Subject: FW: 3/2021/0168

Subject: 3/2021/0168

The parish councils following an email consultation wish to raise the following objections.

1 **Front**
1 : 100

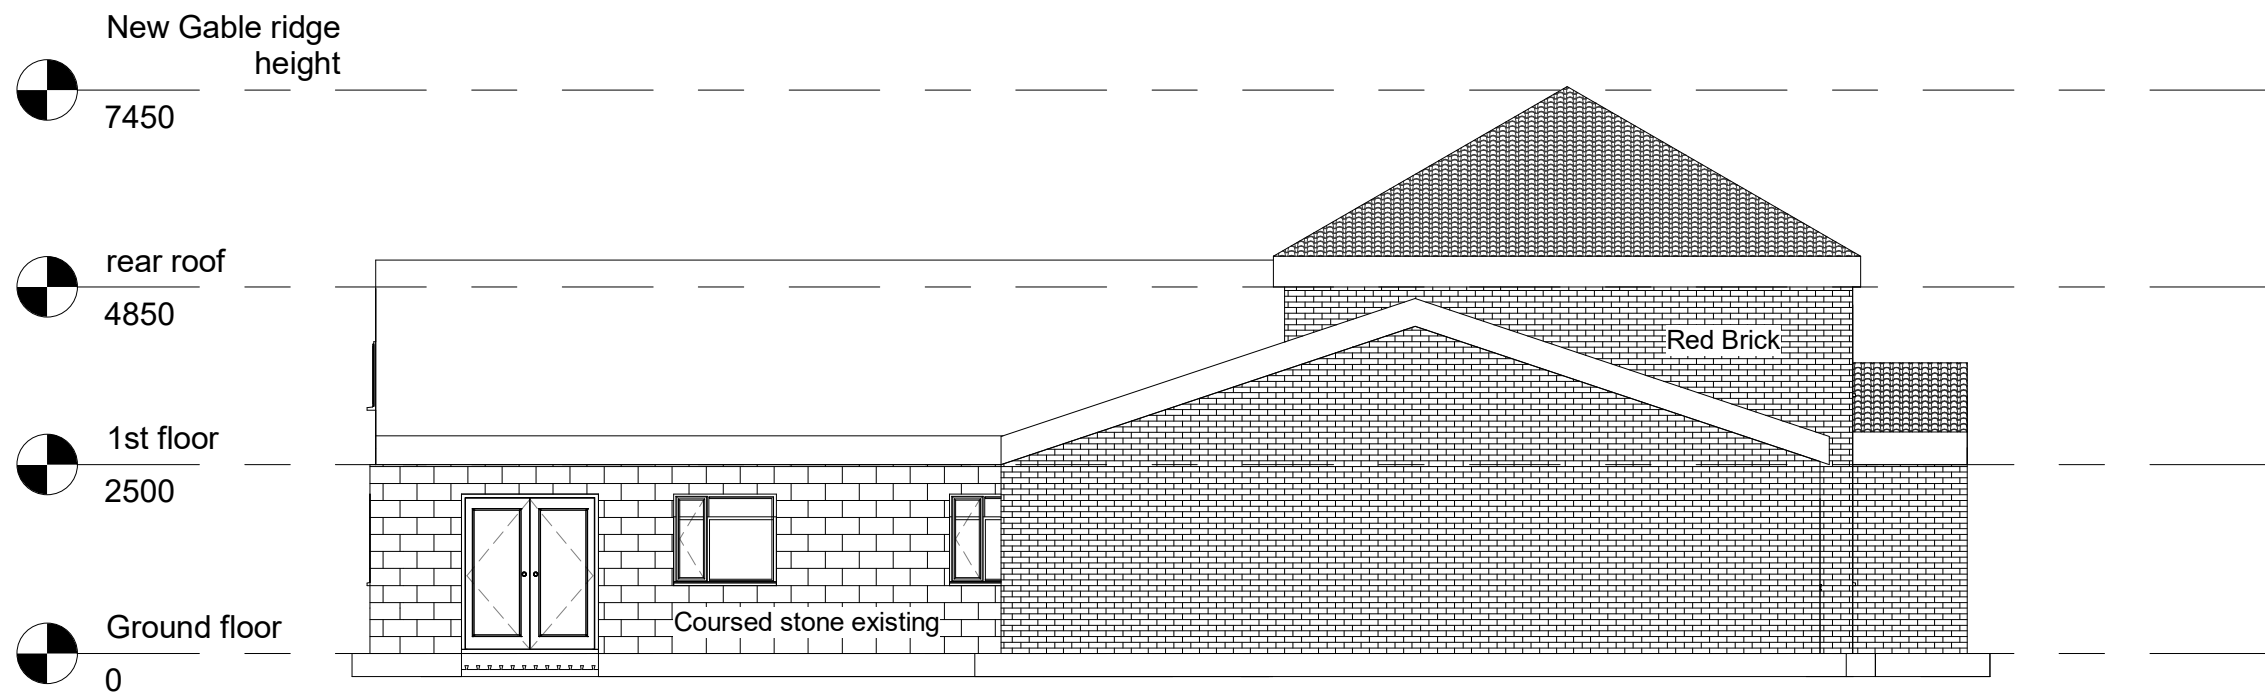
- 1. It gives no reason for replacing the garage doors with 'bi-fold doors' which are what you would normally have as patio doors. It looks like the garage is becoming a living room whilst still being labelled a garage. The front elevation now clearly looks like a living room rather than a garage.
- 2. The plans also increase the number of bedrooms from 4 to 6 without making any reference to this change.
- 3. The render requires changing to brick because of requests from 'neighbouring people'. Nobody on Paris has requested this. The front will already look different to what was approved on the first set of plans and it looks like significant changes are being made under the guise of these variations.
